Our Ref: R/2025/15/C  
File No: 2026/242780  
Your Ref: SSD-93222706

**Advice on EIS – Waterloo Estate (South) Concept – SSD-93222706**

Thank you for your correspondence, dated 4 May 2026, inviting the City of Sydney Council (the City) to comment on SSD-93222706 for the concept approval for the staged redevelopment of Waterloo Estate (South), supported by a concurrent rezoning to modify Sydney Local Environmental Plan 2012 (SLEP 2012) and the Waterloo Estate (South) Design Guide (Design Guide).

Drawing Name
Block 8
 Proposed Envelope -
 Plan

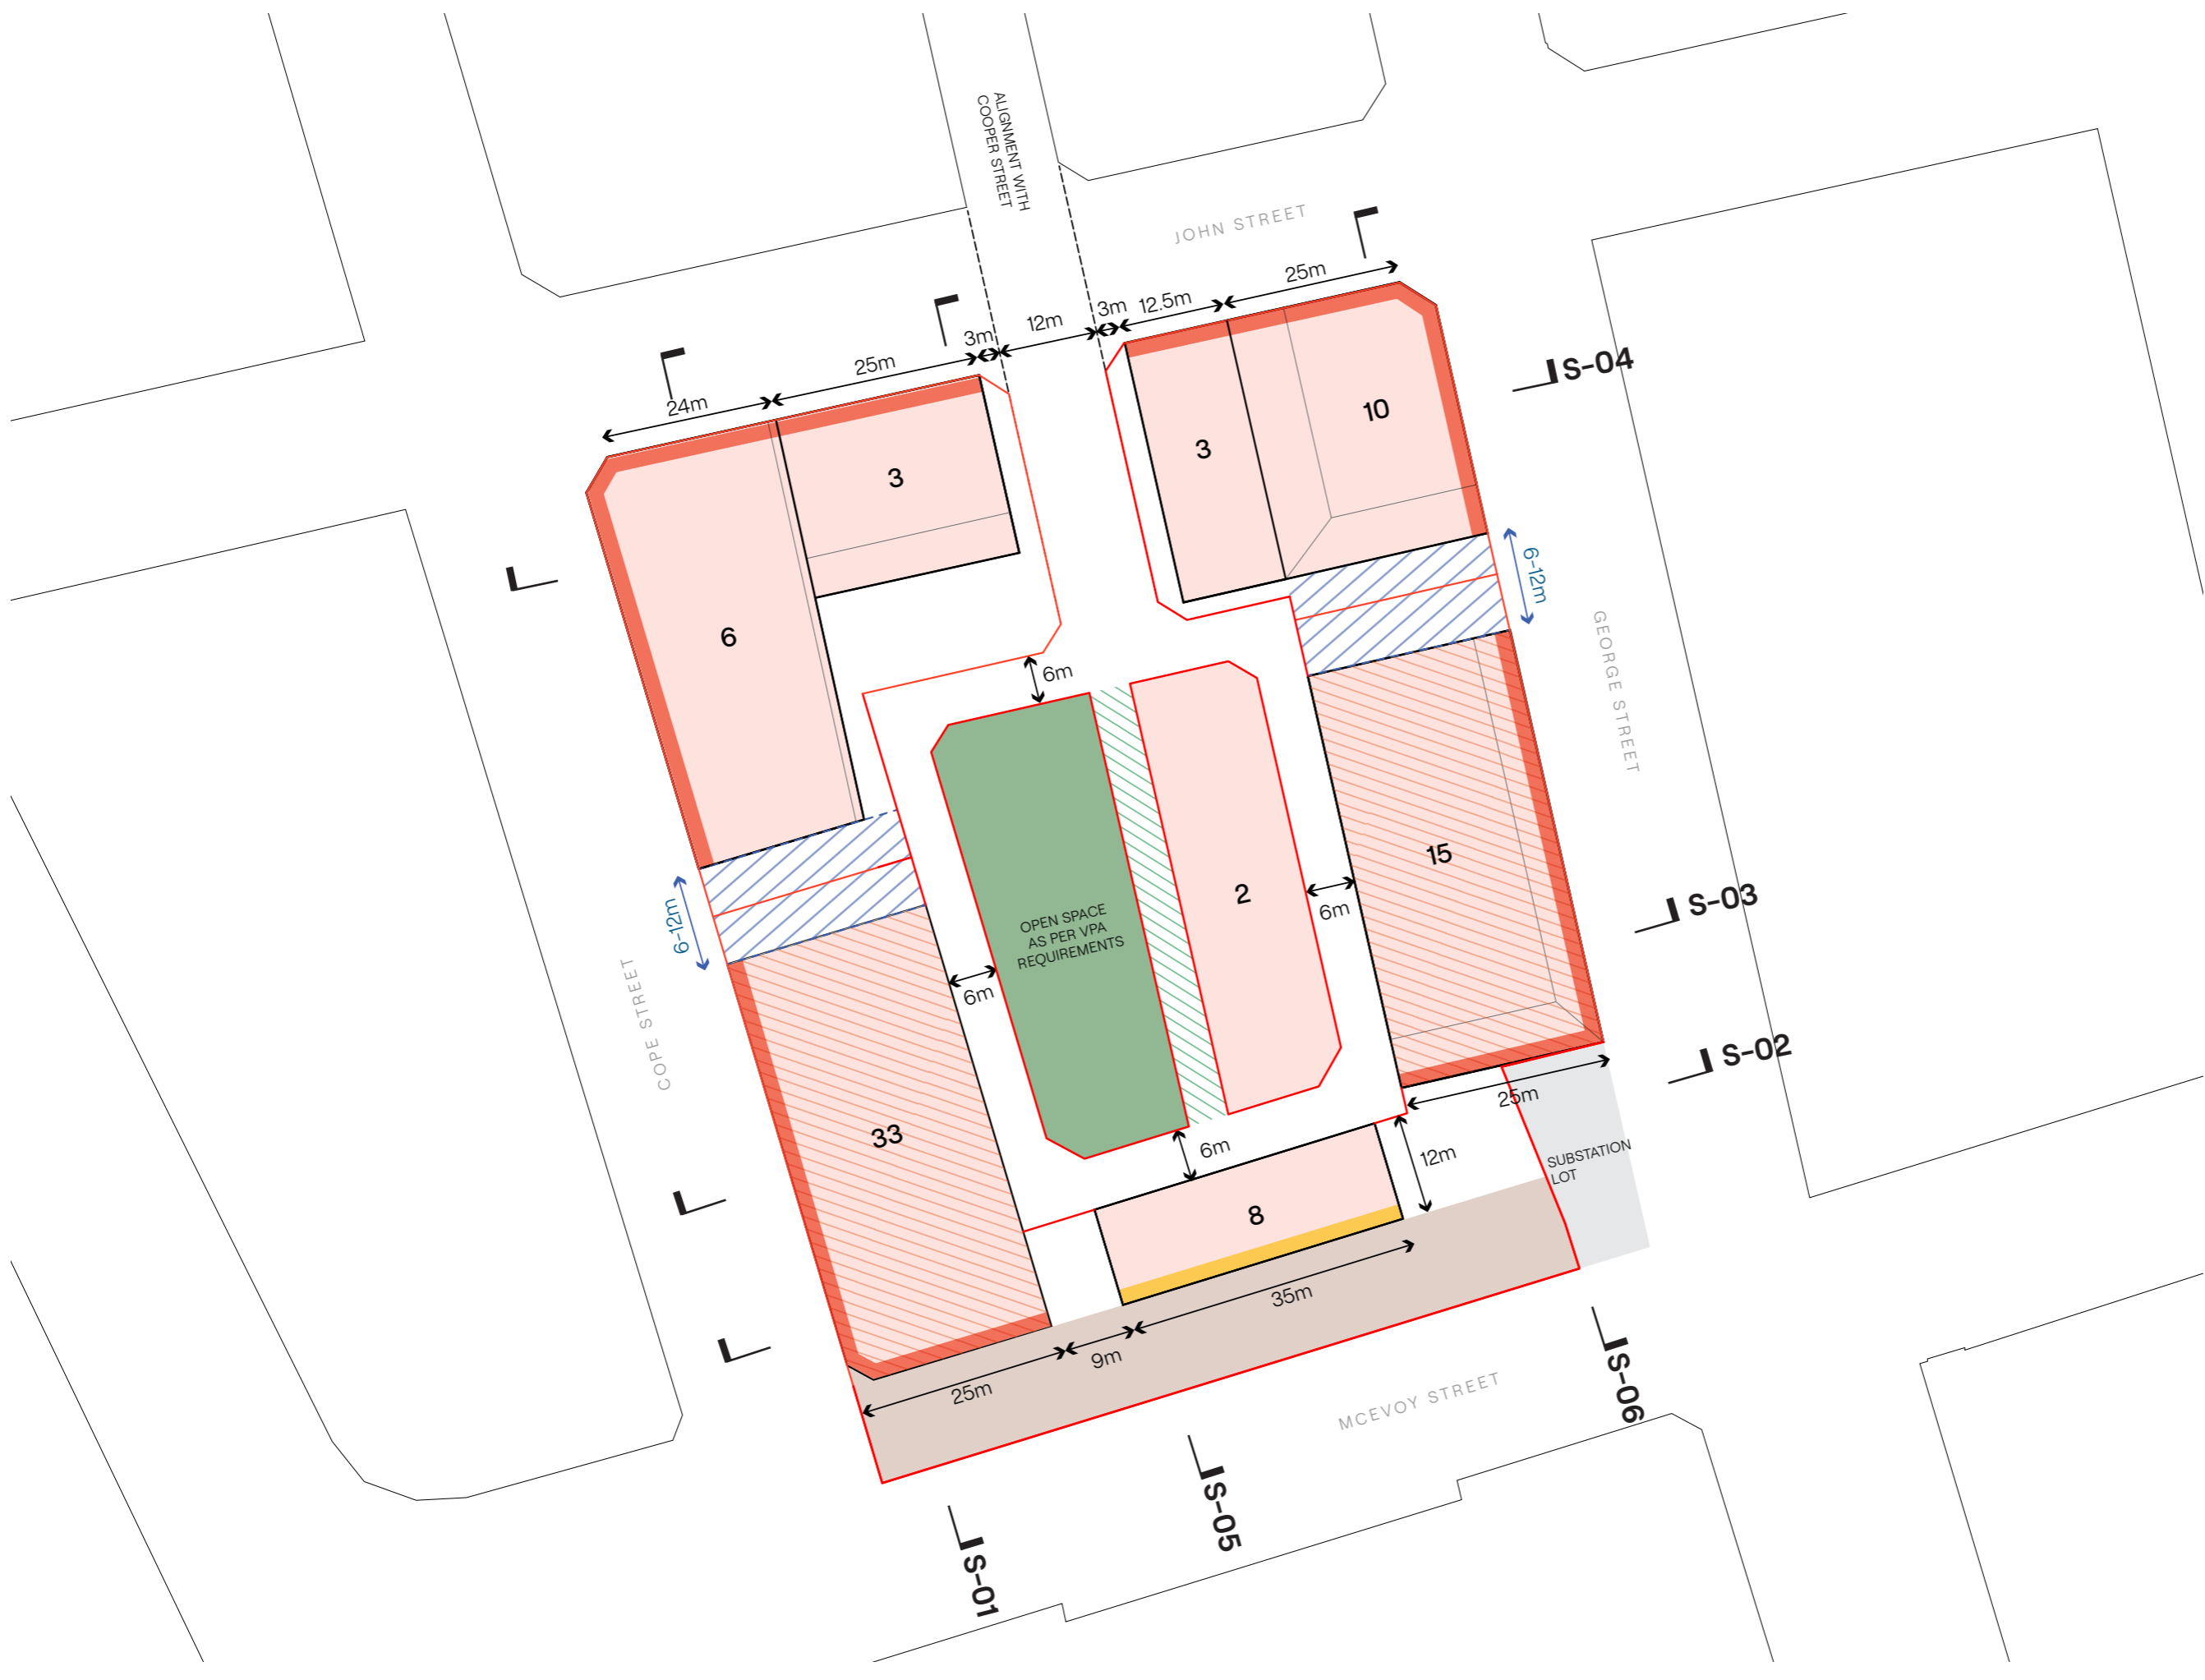
| Block | Proposed LEP height control | Reference scheme height | Recommendation                                                                                                                                                           |
|-------|-----------------------------|-------------------------|--------------------------------------------------------------------------------------------------------------------------------------------------------------------------|
| 8A    | 54m                         | 31m                     | The building fronting McEvoy is much lower than the height control. The control should be split to reflect the proposed form.                                            |

Drawing No.: BL09-AR-2300 Revision: /A

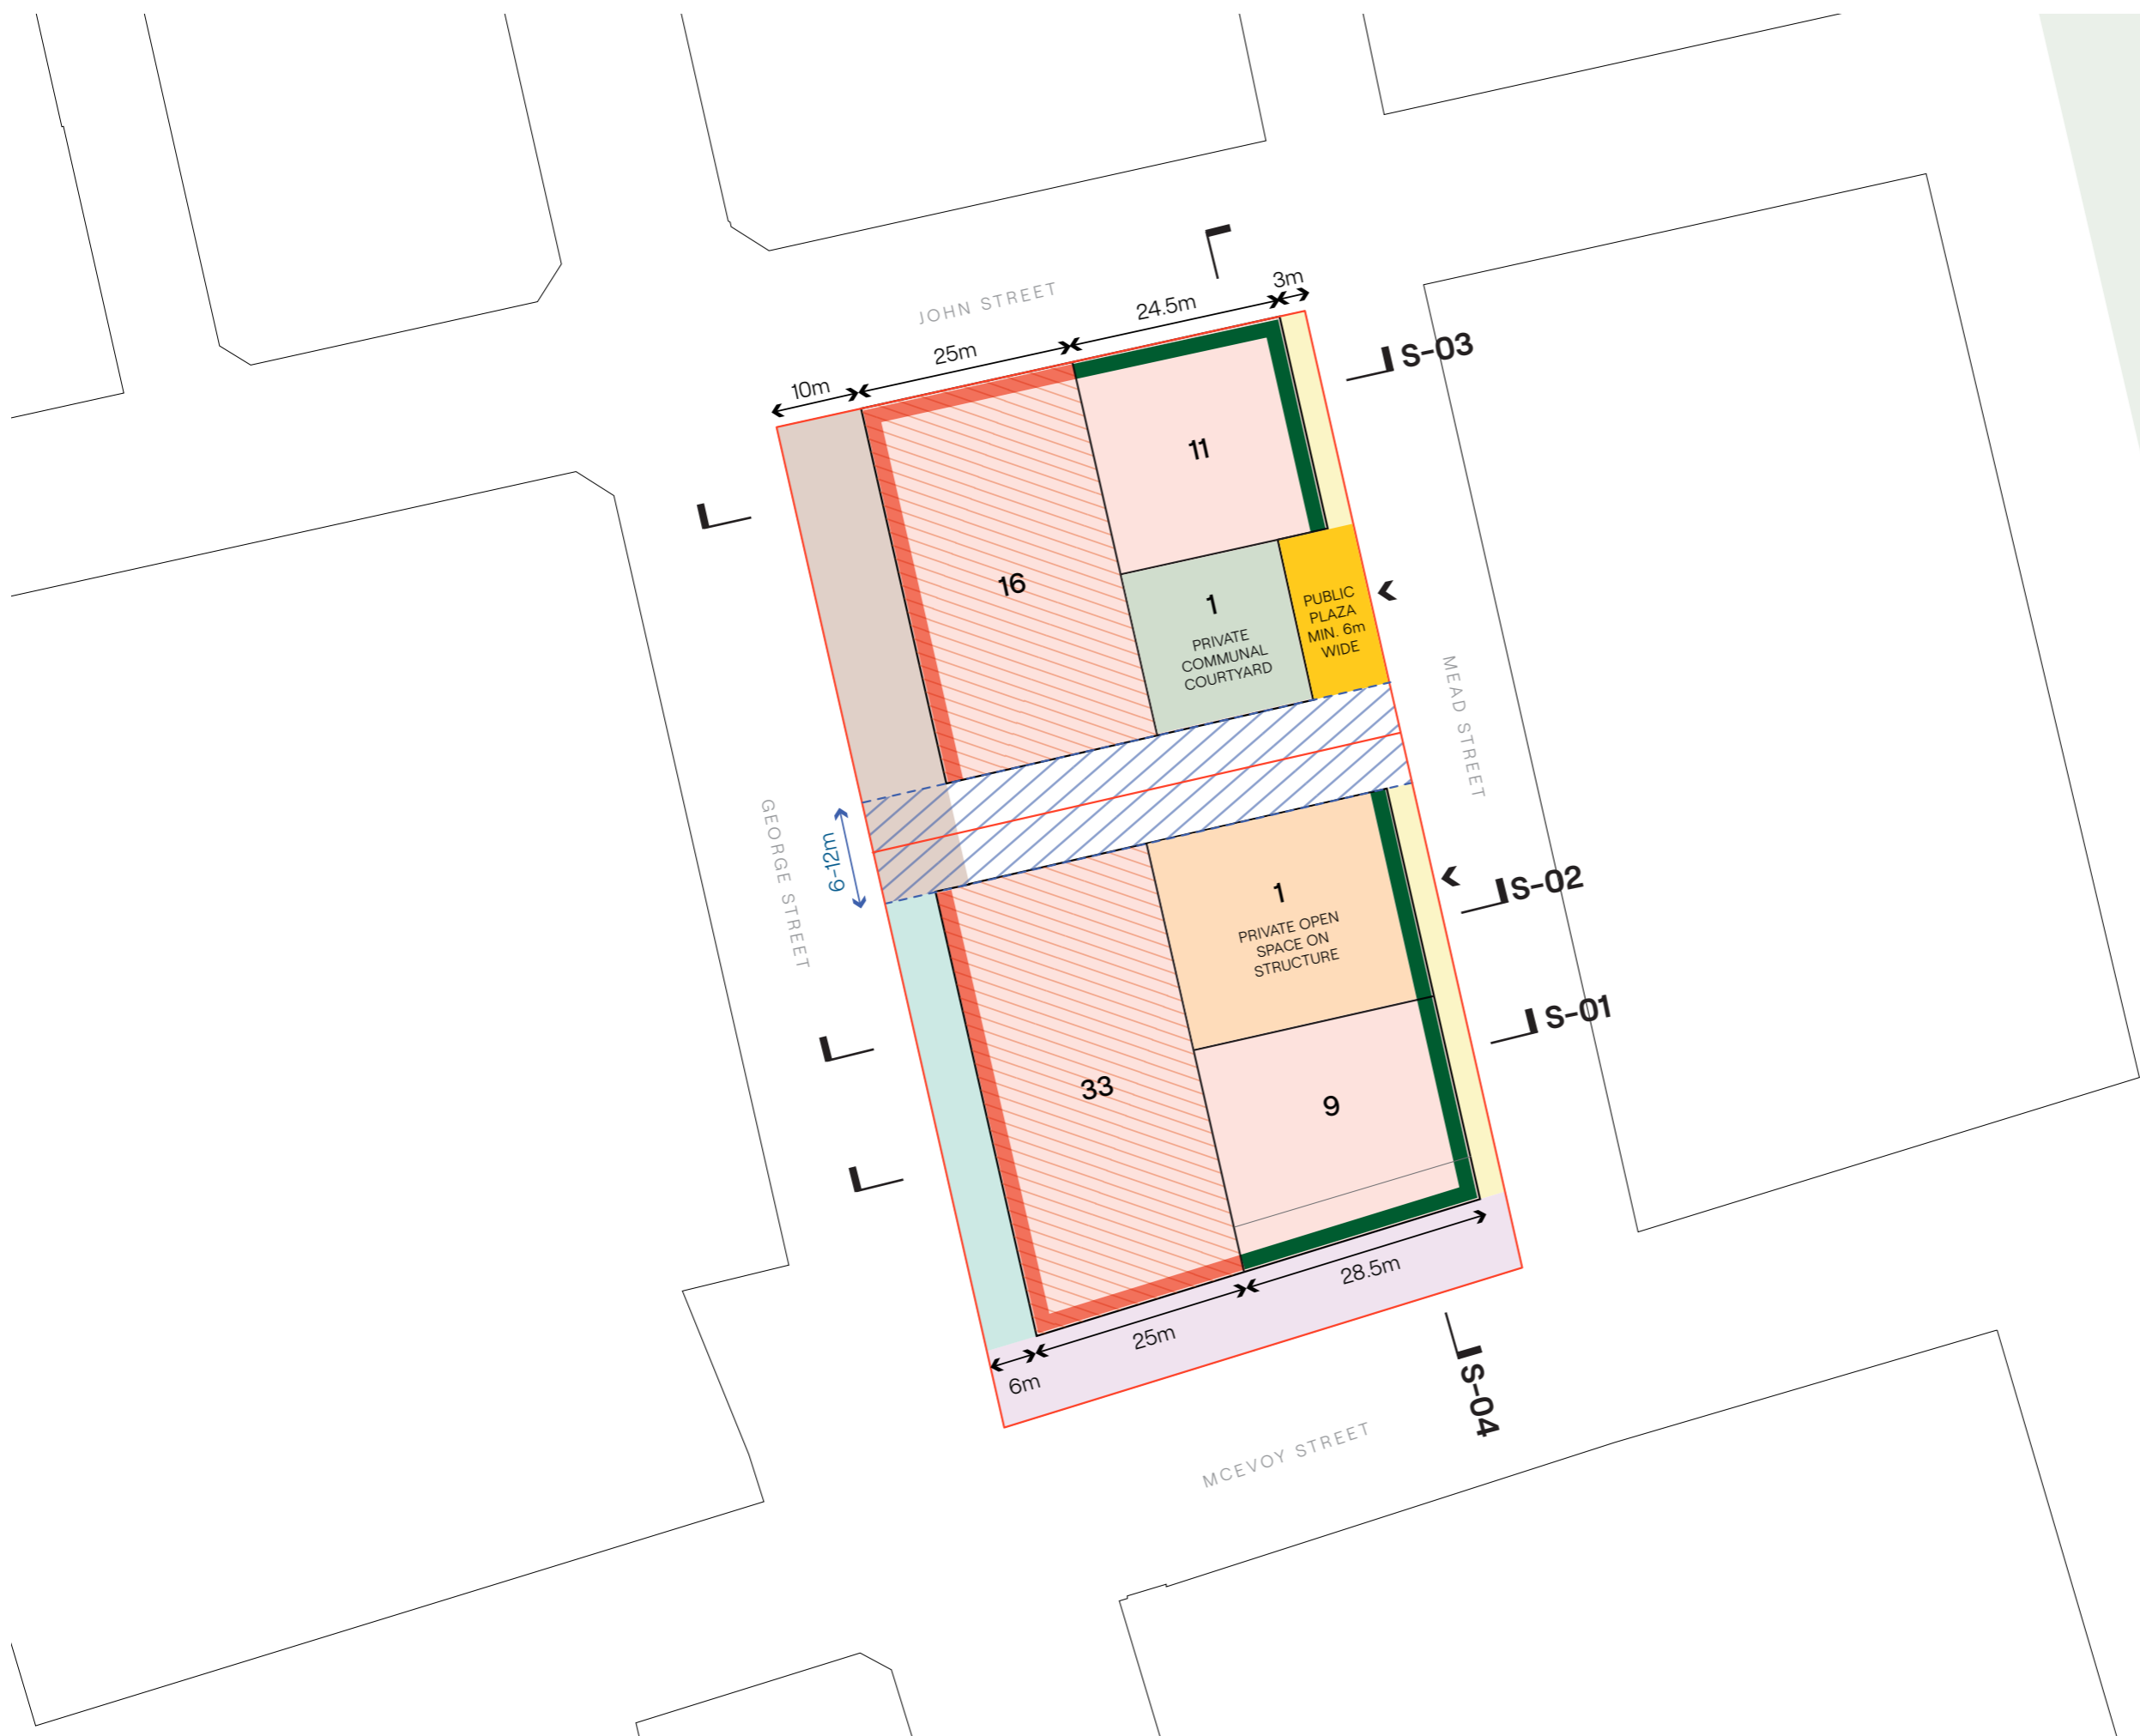
| Block | Proposed LEP height control | Reference scheme height | Recommendation                                                                                                                                                           |
|-------|-----------------------------|-------------------------|--------------------------------------------------------------------------------------------------------------------------------------------------------------------------|
| 9B    | 56m                         | 40m                     | The eastern part of the block should have a lower height control to reflect the lower proposed form.                                                                     |
